Development Facilitation Team (DFT) – Review Comments

Project No: PR-2024-010189 Date: 2/26/2025 Agenda Item: #1 Zone Atlas Page: (H-8, J-7, J-8)

Request: Subdivide Tract N-1 into two tracts

Location: 9601 Tierra Pintada Blvd between Tierra Pintada Blvd NW and Arroyo Vista Blvd NW

MIREHAVEN PKWY

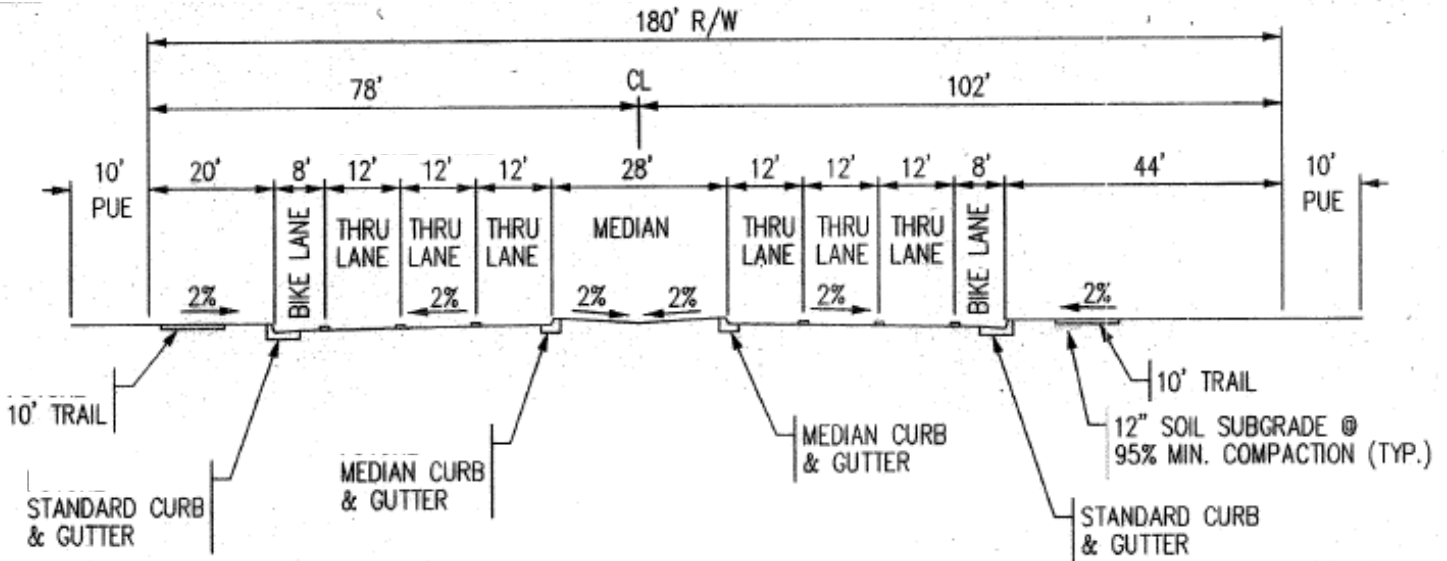
1. The cross sections provided show adequate sidewalk or trails for all roadways, though the landscape buffer for Mirehaven appears to be only 2' wide. Transportation defers to Parks and Planning if this is acceptable. No objections.
